Appendix D – Detailed Response to Submissions

Table 1 DPHI Request for Information

Table 2 Agency Submissions

Construction of new exhibition floor.

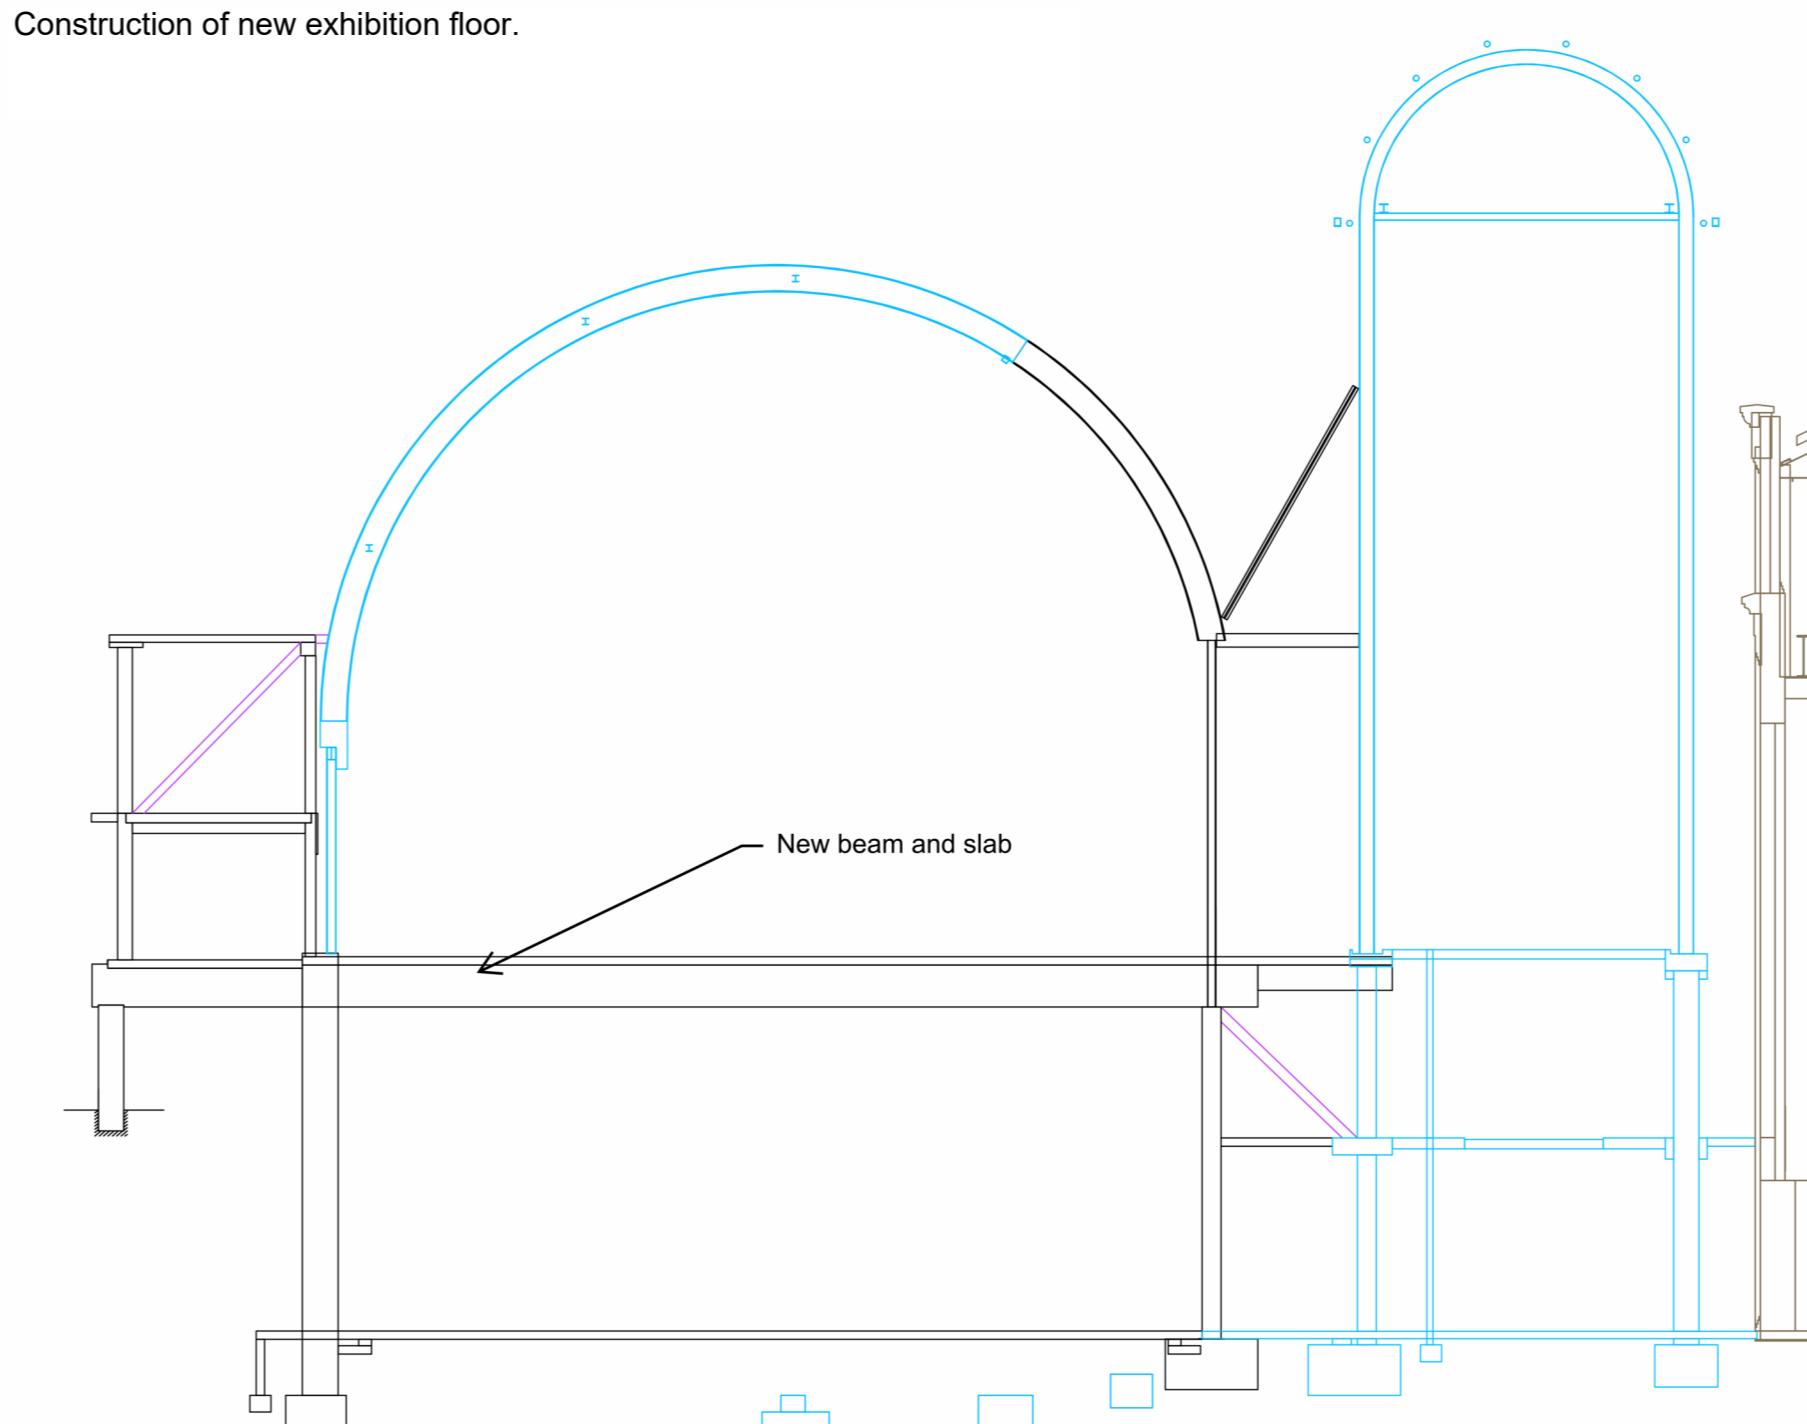
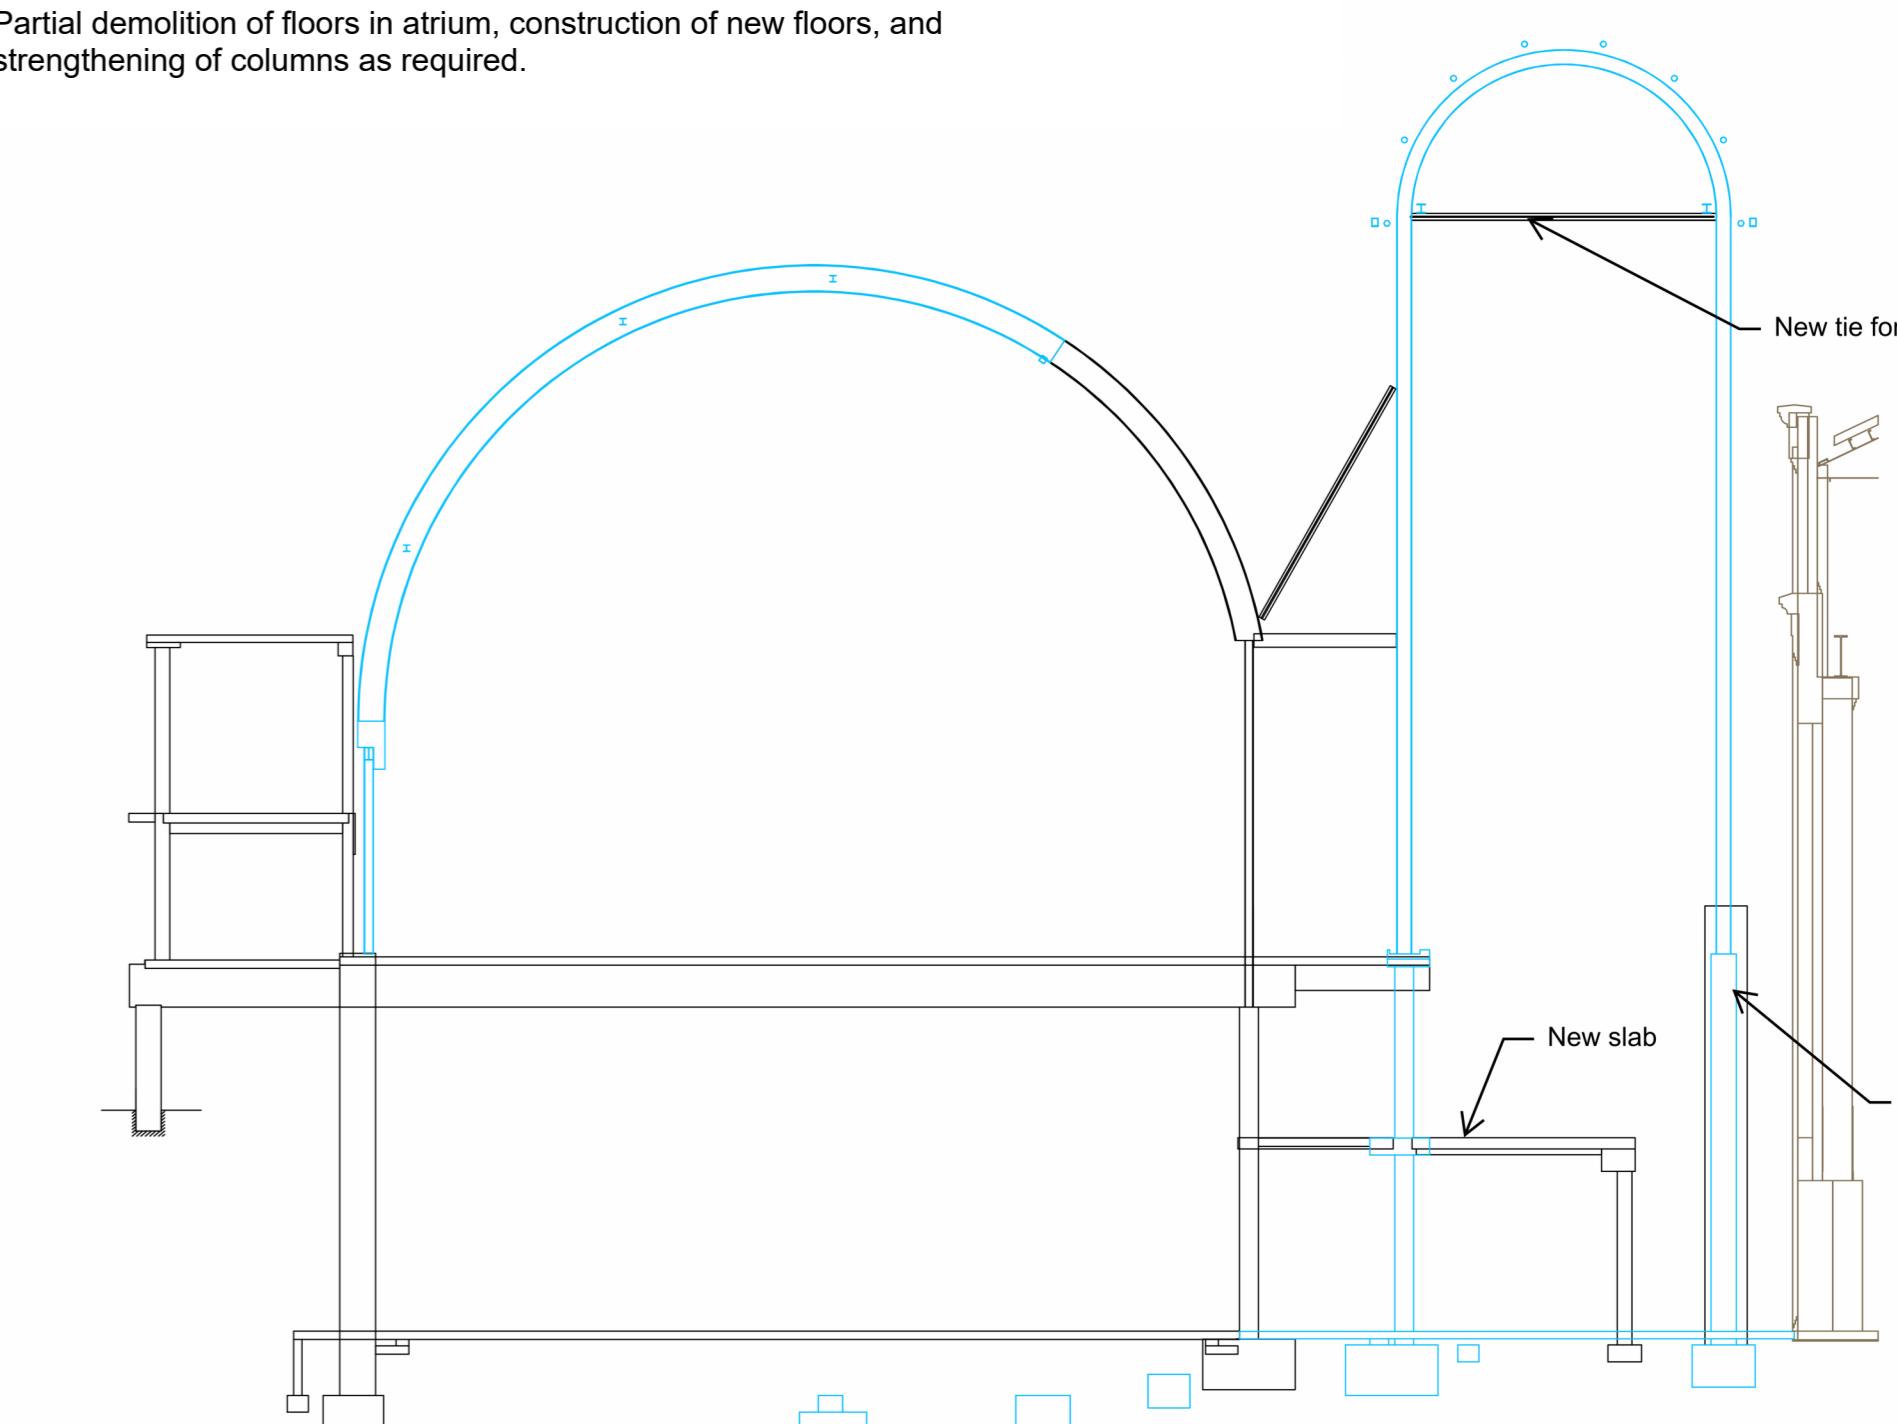
<ul style="list-style-type: none"> - Clarification is required as to whether the intent is to retain the existing roof form and structure and how this would be extended to complete the arch of the barrel. The materiality of the roof is also to be clarified with the continuing use of a high durable long life; lightweight metal roof preferred. Galvanic reactions between dissimilar metals must be avoided or managed. - The demolition of the lower-level colonnade associated with the Wran Hall allows creative industry spaces to be provided along and activate Harris Street. This is supported; however, the spaces would be disconnected from the Powerhouse Museum and servicing and waste removal needs to be further considered. 	<p>finishes. In relation to heritage impact, the amended HIS provides further assessment of these materials.</p> <ul style="list-style-type: none"> • Refer to Amended Design Report at Appendix F. • Servicing of the Creative Industries spaces will need to occur from the Harris Street frontage. The waste servicing requirements for the users of this space will be extremely low and comparable to a typical office use. Emptying of waste would occur on a daily basis by each tenant taking waste to the central waste room within the loading dock. It is expected that each tenancy will be provided with a 10L bin. • Waste reduction initiatives as part of the submitted ESD Report at Appendix BB of the EIS include a commitment to 80% of construction and demolition waste to be recycled by the head contractor.

CoS10	<ul style="list-style-type: none"> • Materials and Building Expression <ul style="list-style-type: none"> - There is only a very limited palette of materials shown on the architectural drawing set - The design report also includes garden mesh and aluminium cladding - The design report also references 'The new built form will be comprised of a mix of recycled and new bricks, brick slips, stone, ceramics, glass, metal cladding and class 2 in situ concrete and precast concrete.' - The proposed materials and finishes need to be further clarified and the drawings should be amended to clarify materials and key these to the elevations and sections. This is also requested to assist in assessing the potential heritage impacts of the additions. - The design of the Wran hall and galleria adaption is generally supported; however, more information is required to understand the amount of demolition and retention of structure. - The northern and southern ends of the Wran hall and the galleria are shown in elevations as brick. More information is required regarding the construction and structural delivery of brick ends to the existing steel super structure. The roof skin is also to be clarified, it is unclear from the renders, what this is intended to be. 	<ul style="list-style-type: none"> • The Amended Design Report at Appendix F to this Submissions and Amendments Report provides further details on the proposed materials and finishes. In relation to heritage impact, the Amended HIS (Appendix L) provides further assessment of these materials. Details regarding the extent of demolition of internal areas within the Wran Building are included within the Structural Sequencing diagrams contained at Appendix H to this Submissions Report.

Right: Plan illustrating the revised layout of the Post Office Courtyard. Soil extents are described in the Soil section on subsequent pages.

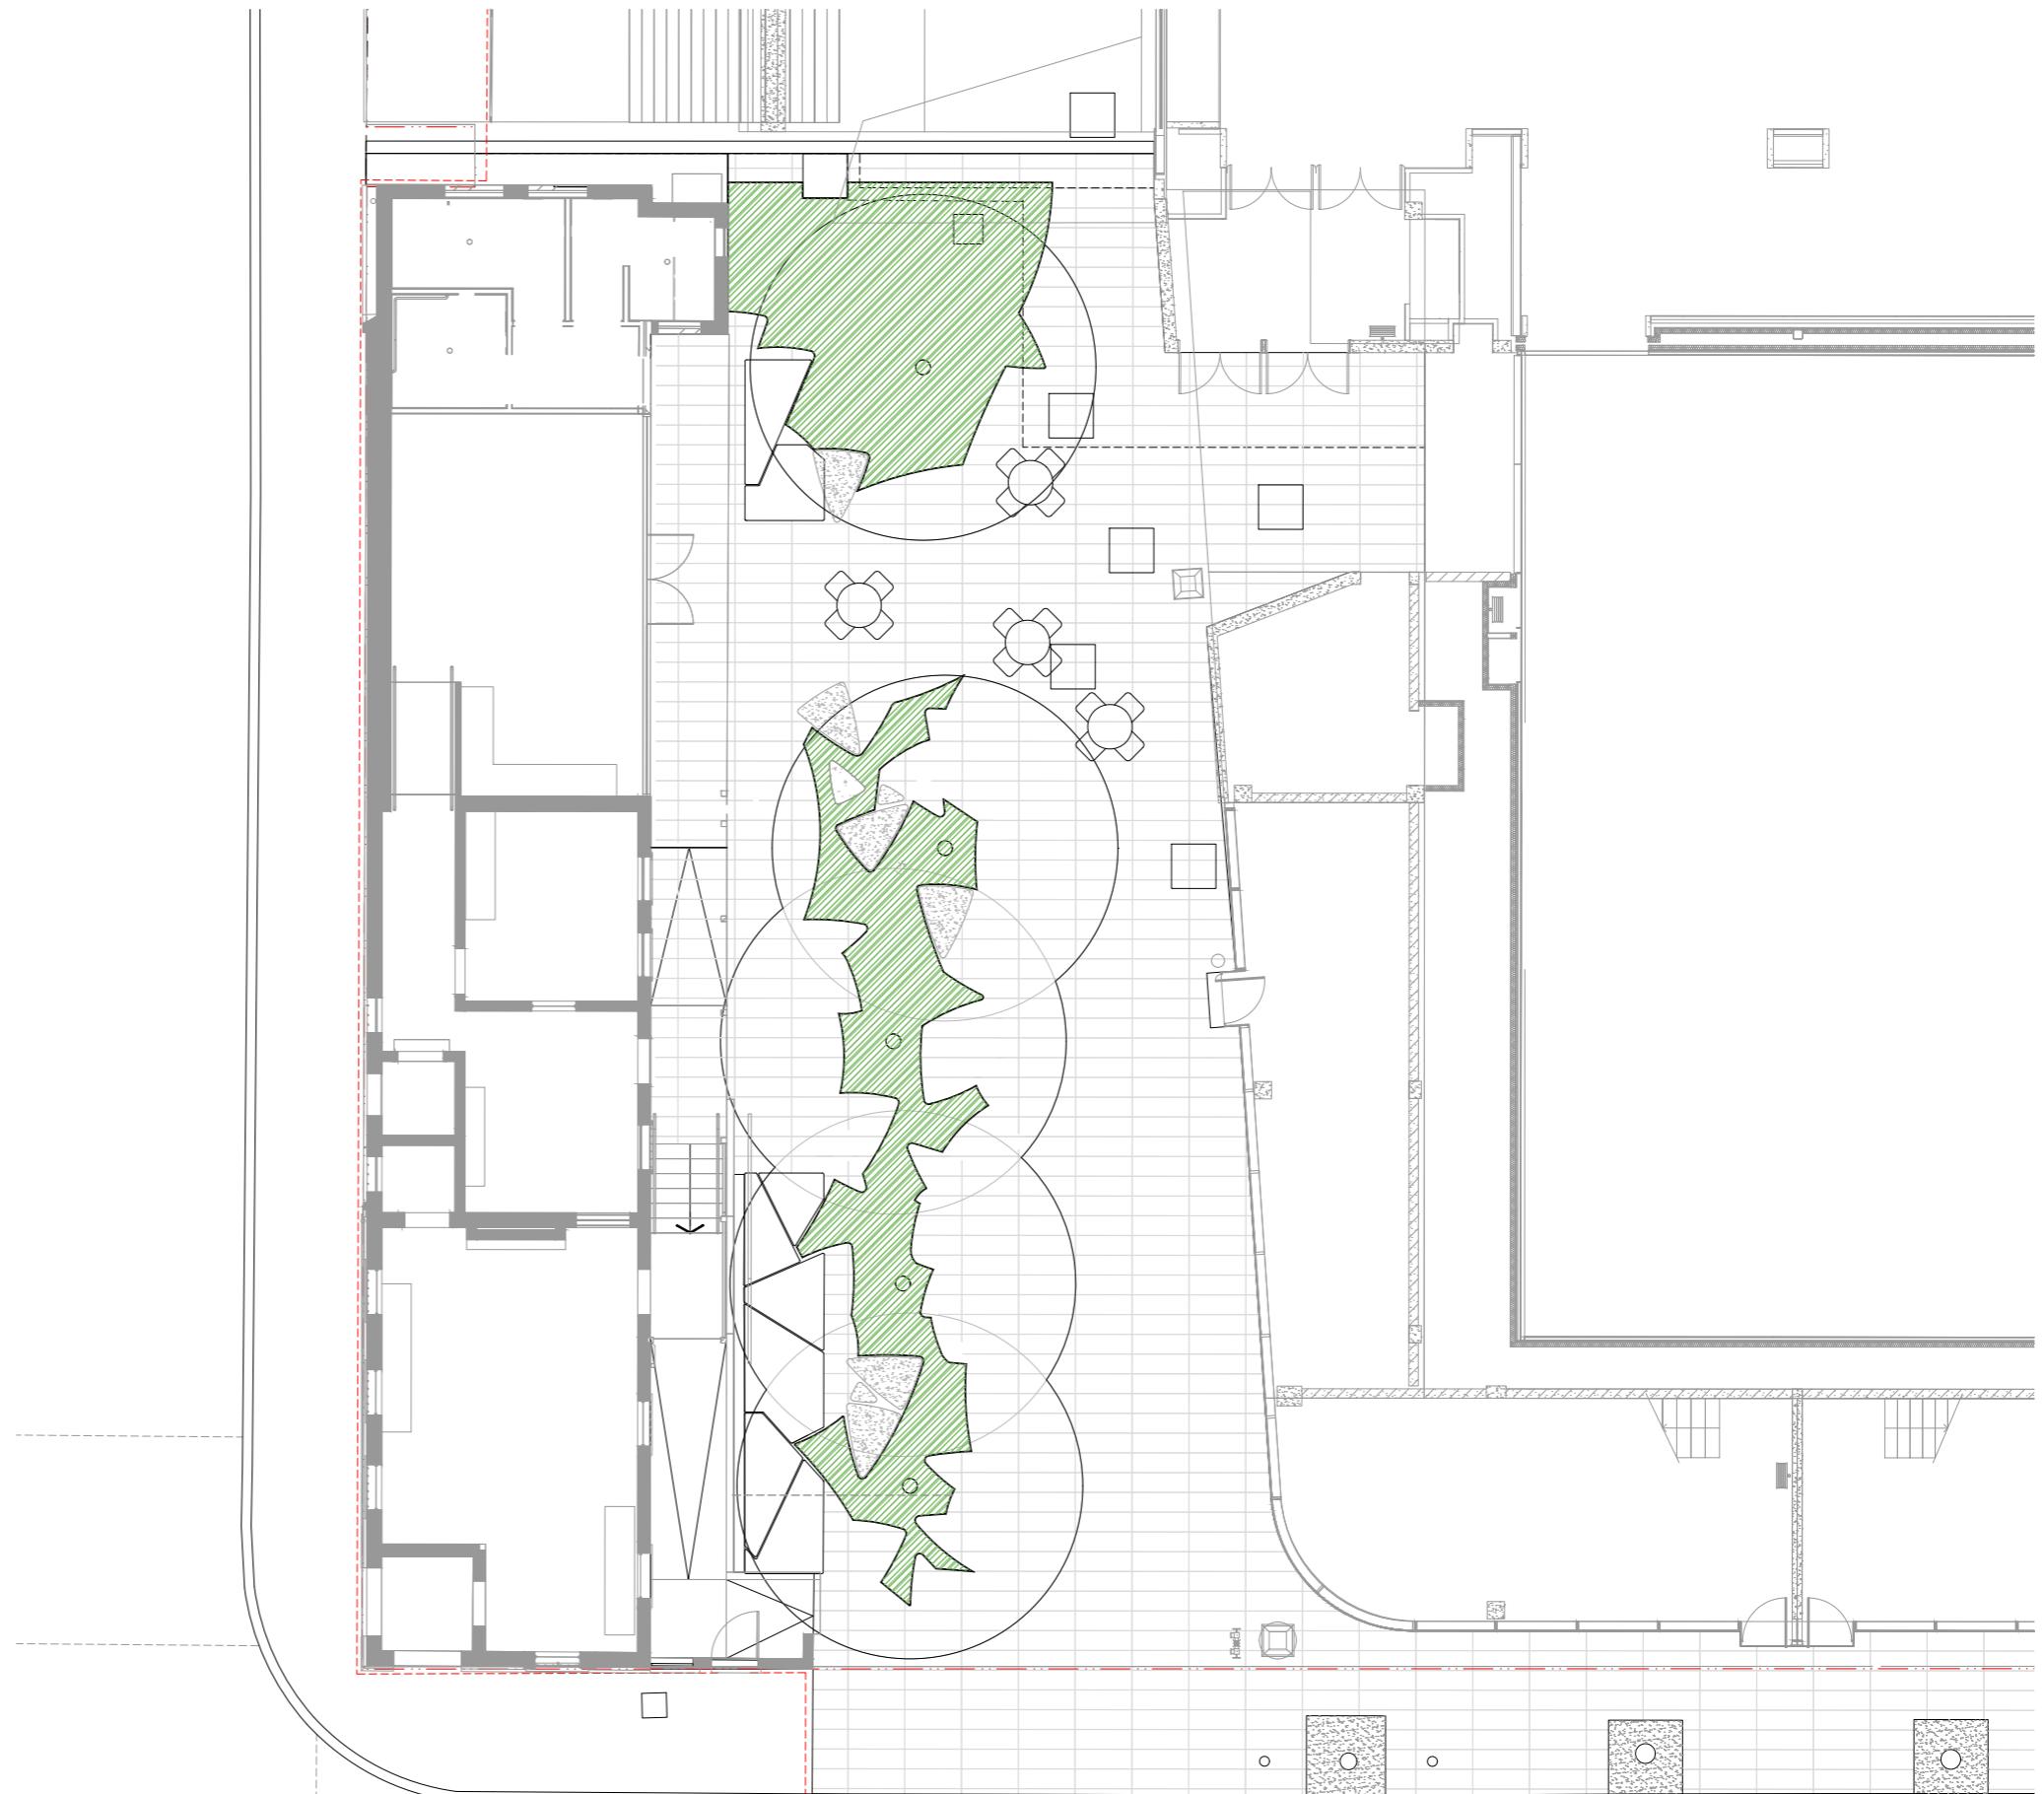
<ul style="list-style-type: none"> - A grove of 15 new <i>Eucalyptus racemosa</i> is proposed to be planted in the post office courtyard within paving. The landscaping concept is supported in principle; however, further clarification is required regarding the design, including: <ul style="list-style-type: none"> whether tree grilles or similar are provided whether pavement is proposed to be rigid or permeable the design of the tree pits 	<ul style="list-style-type: none"> • There are no tree grilles, rather, the concept is for the Angophoras to emerge from a planted fracture in the hardscape • The trees will be provided ample structural soil beneath permeable pavers
CoS24	<ul style="list-style-type: none"> • Landscape Drawings <ul style="list-style-type: none"> - The landscape drawings include a concept paving and planting design only. The package does not demonstrate that the design of landscaping on structure allows for adequate soil depth and soil volume to support trees to maturity and proposed understorey planting. - To provide a full assessment of the landscape and public domain located in outdoor spaces located within the project boundary, the City requires a more complete set of plans. - Landscape Plans should include: <ul style="list-style-type: none"> levels (RL, SSL, TW) amended resolved plant schedule with tree pot size, understorey species, pot size or rate per m² materials schedule details for softworks at grade, trees in structural soil and planters on structure details for hard works including paving types, stairs, ramps, balustrades, and elements outline maintenance schedule including responsibility for the ongoing of highly used, traffic and visible landscape plant procurement strategy for grassland species. 	<ul style="list-style-type: none"> • This comment has been addressed within the Amended Landscape Plans at Appendix N to this Submissions and Amendments Report.

CoS23	<ul style="list-style-type: none"> • Post Office Courtyard 	<ul style="list-style-type: none"> • The design of the Post Office Courtyard has been updated to include <i>Angophora costata</i> trees (refer to CoS20).
